From: Amanda Scholes on behalf of Planning.Responses
Sent: 28 June 2019 09:39
To: Planning Scanning
Subject: FW: LU/96/19/CLP

Proposed Front Elevation (West)
1:100

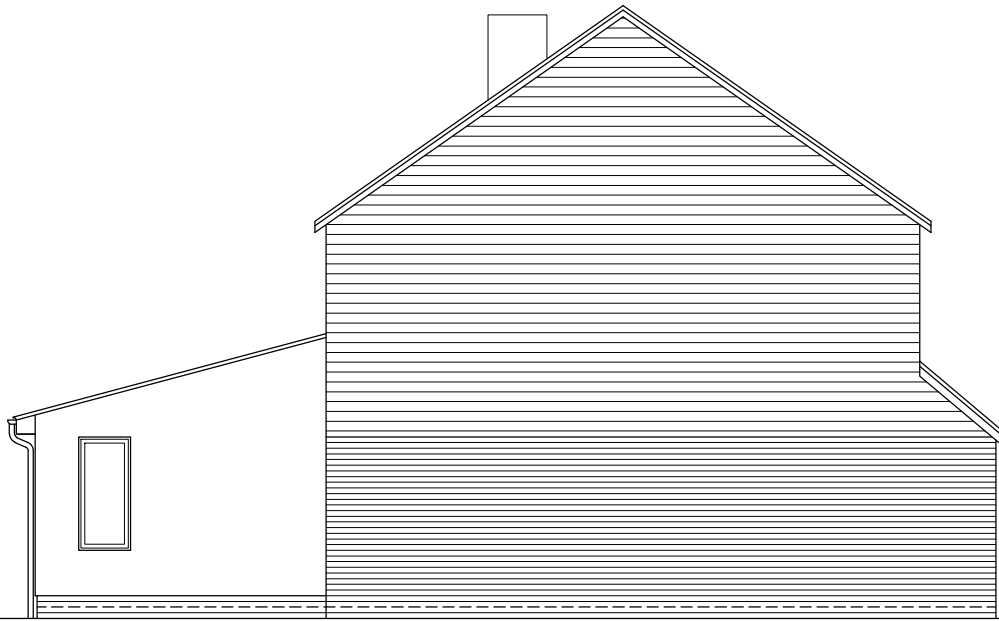
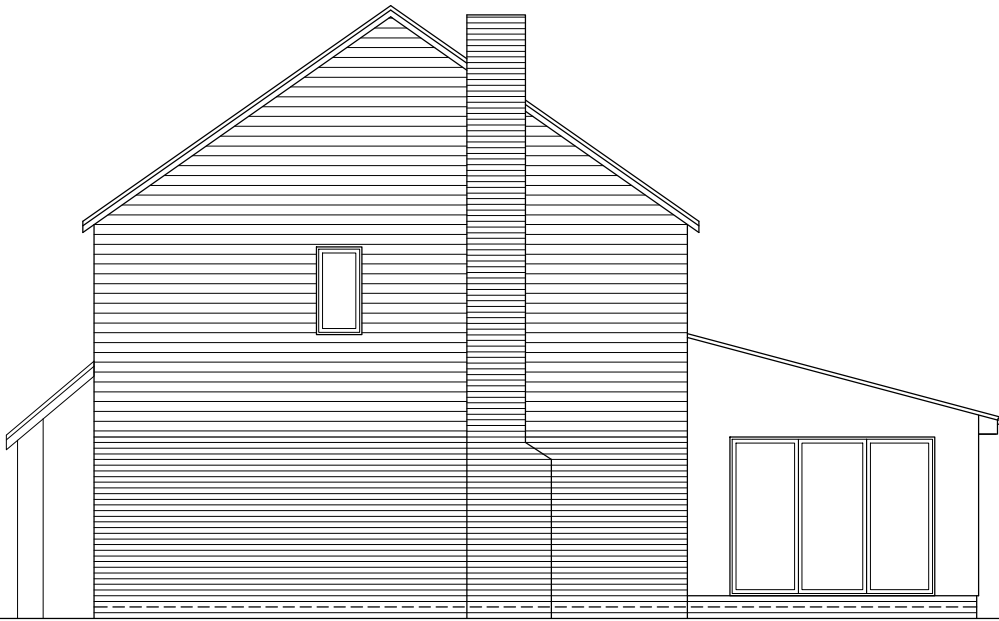
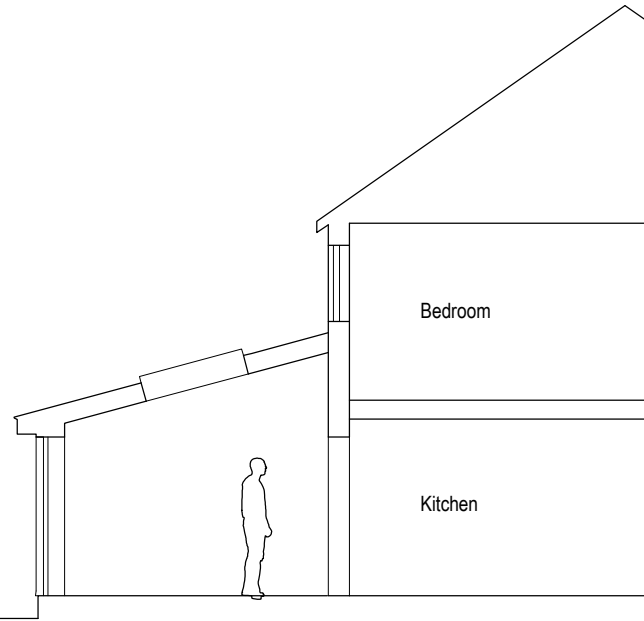
SCHEDULE 2 Part 1 a.3 (a) of the GDPO states that 'the materials used in any exterior work (other than materials used in the construction of a conservatory) must be of a similar appearance to those used in the construction of the exterior of the existing dwelling house.'

This means that where the materials proposed are not of a similar appearance to those used in the construction of the exterior of the existing dwellinghouse, as they are proposed in this case, then the application would need to be refused. If you wish to pursue this use of materials then you will have to submit a planning application.

I am emailing regarding the lawful development certificate for a single store rear extension. As it is from the information available it is set to be refused. This is due to the materials that are proposed to be used. The GDPO explains that the materials that should be used should be similar to those of the existing, from what I can see it seems the windows are White PVC not grey aluminium slim profile- walls are red brick not smooth white render and low level blue grey brick- roof seems to be red tiles rather than fibre cement slates.

Walls - Red brick to match existing property.

Roof - Red tiles to match existing property.

Windows - White PVC to match existing.
